Permit No: 06-0725	Issue Date:	CBL: 058 A008001
------------------------------	--------------------	----------------------------

Location of Construction: 92 SALEM ST	Owner Name: TITHERINGTON TARI & OLIVE L S	Owner Address: 92 SALEM ST	Phone:
Business Name:	Contractor Name: Peter W Hudson	Contractor Address: P O box 340 E Waterboro	Phone 2072474706
Lessee/Buyer's Name	Phone:	Permit Type: Alterations - Commercial	Zone:

Past Use: Residential 3 unit (condo)	Proposed Use: Residential 3 unit (condo) add dormer to 3rd floor, 3rd floor stairs to code, rear decks to code, 2 kneewalls to 3rd floor	Permit Fee: \$174.00	Cost of Work: \$17,000.00	CEO District: 2
Proposed Project Description: Add dormer to 3rd floor, 3rd floor stairs to code, rear decks to code, 2 kneewalls to 3rd floor		FIRE DEPT: <input type="checkbox"/> Approved <input type="checkbox"/> Denied	INSPECTION: Use Group: Type	
		Signature:	Signature:	
PEDESTRIAN ACTIVITIES DISTRICT (P.A.D.)				
Action <input type="checkbox"/> Approved <input type="checkbox"/> Approved w/Condition <input type="checkbox"/> Denied				
		Signature:	Date:

# THIRD FLOOR PLAN "AS PROPOSED"

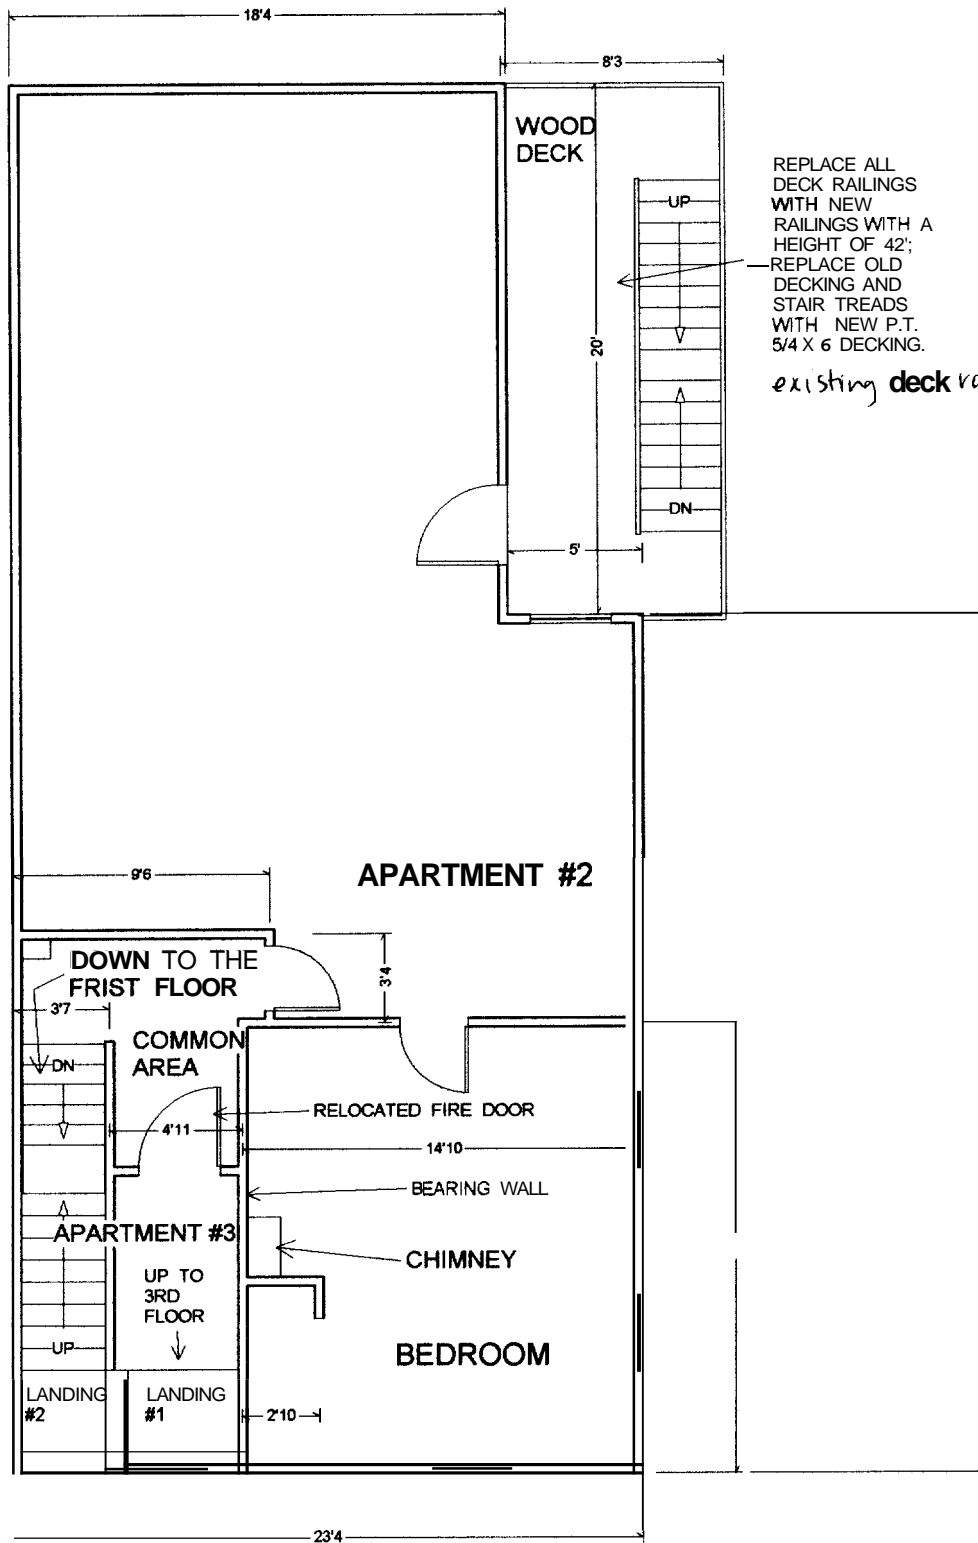
1) Framing details for the stair floor opening must be submitted and approved, prior to framing. Guard details must be submitted and approved prior to construction.

3) New stairway must have 80 inches of headroom.			
4) The communicating stairway from the second to the third floor unit is "within" the dwelling unit and thus is entitled to have a 7 3/4 inch riser and 10 " tread.			
Dept: Fire	Status: Approved with Conditions	Reviewer: Cptn Greg Cass	Approval Date: 05/31/2006
Note:			Ok to Issue: <input checked="" type="checkbox"/>

# CROSS SECTION OF PROPOSED NEW DORMER

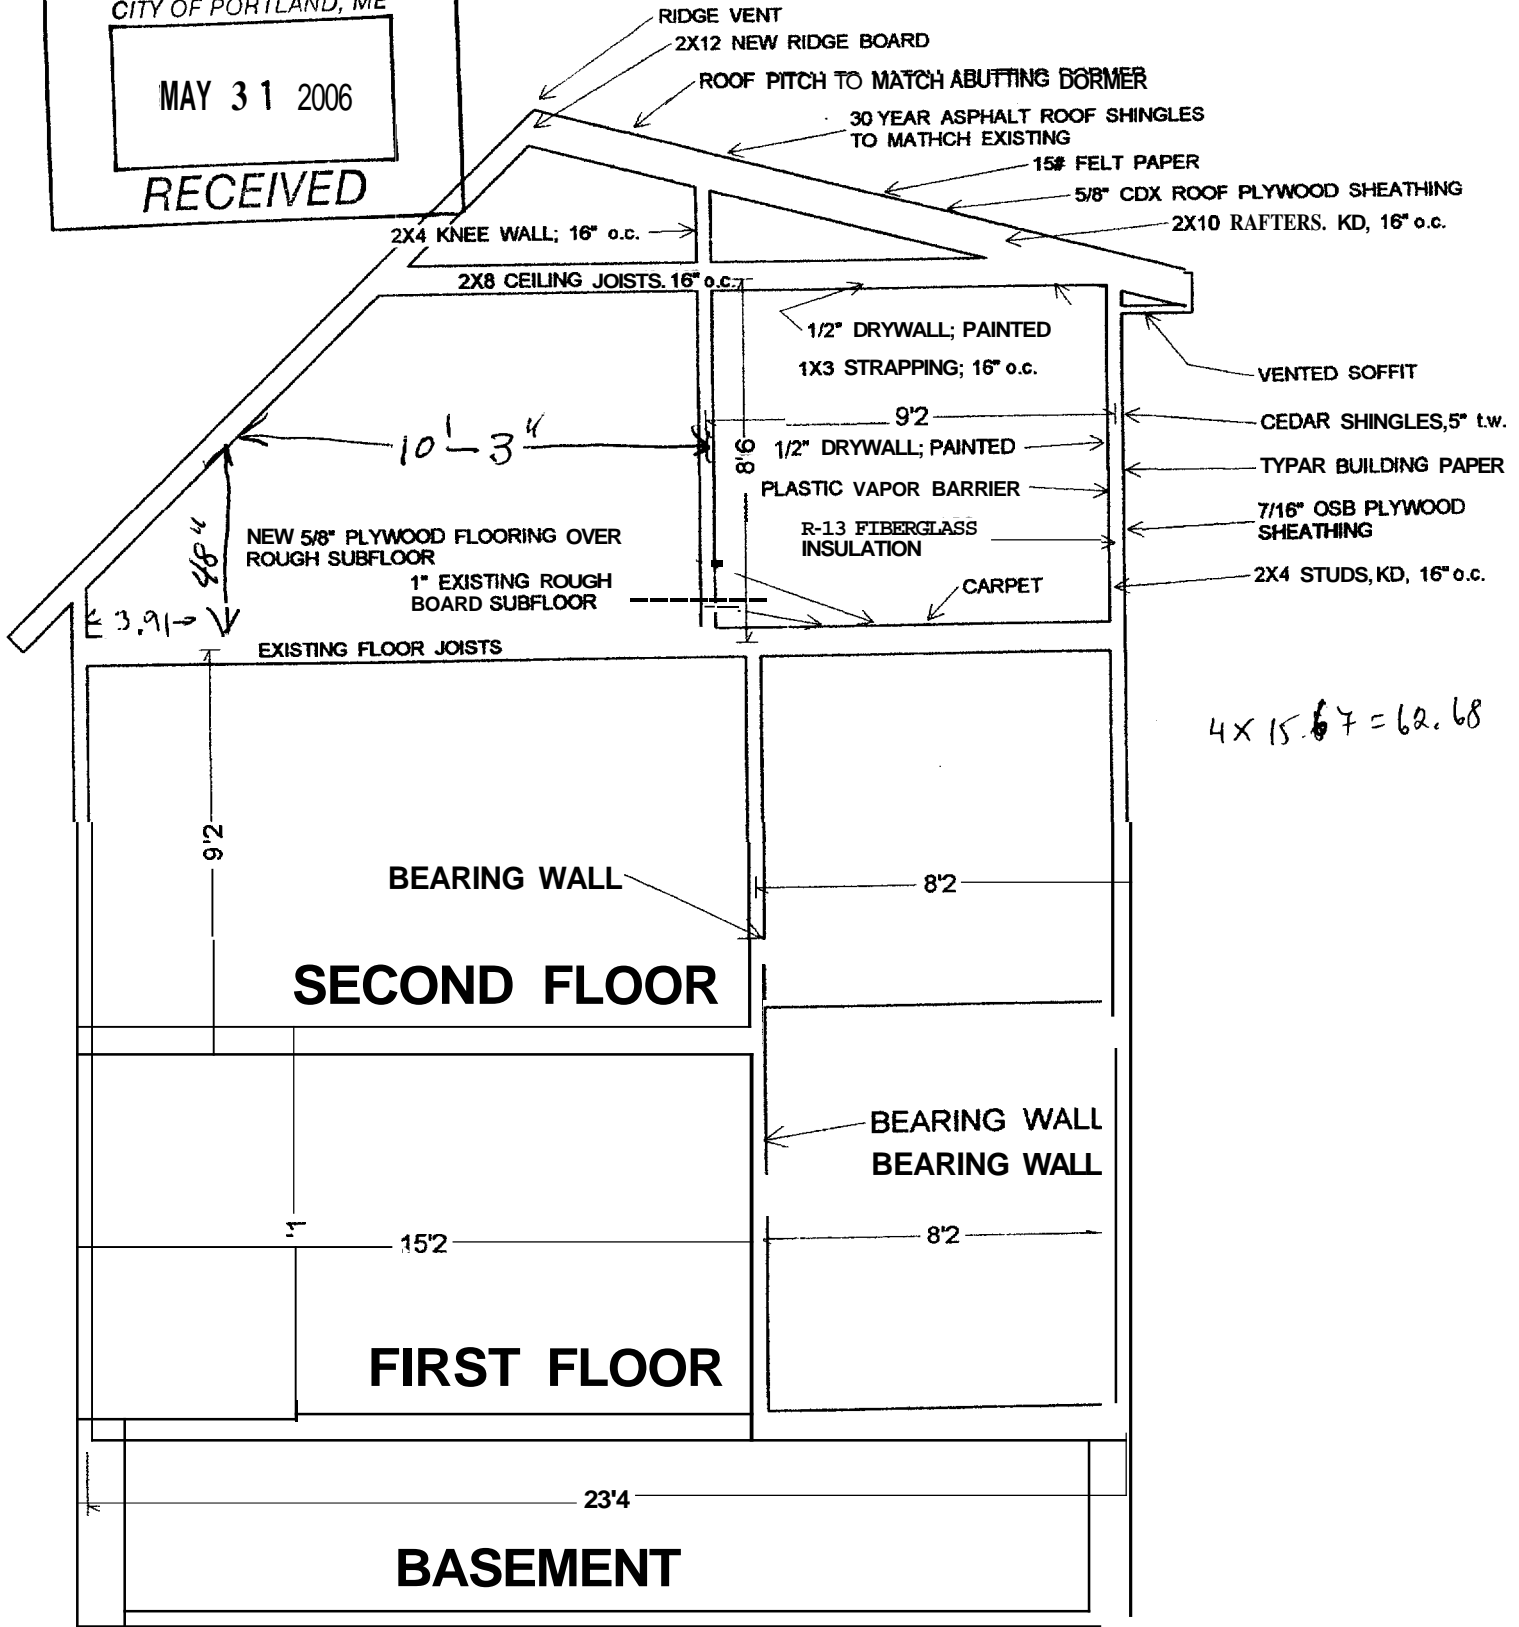
Dept: Zoning	Status: Approved with Conditions	Reviewer: Ann Machado	Approval Date: 05/31/2006
Note: Section 14-433(b) allows for an 80% increase of first floor footprint. 80% is 1303.75 s.f. Dormer is 63 s.f. Increase or 6% of allowable increase			Ok to Issue: <input checked="" type="checkbox"/>
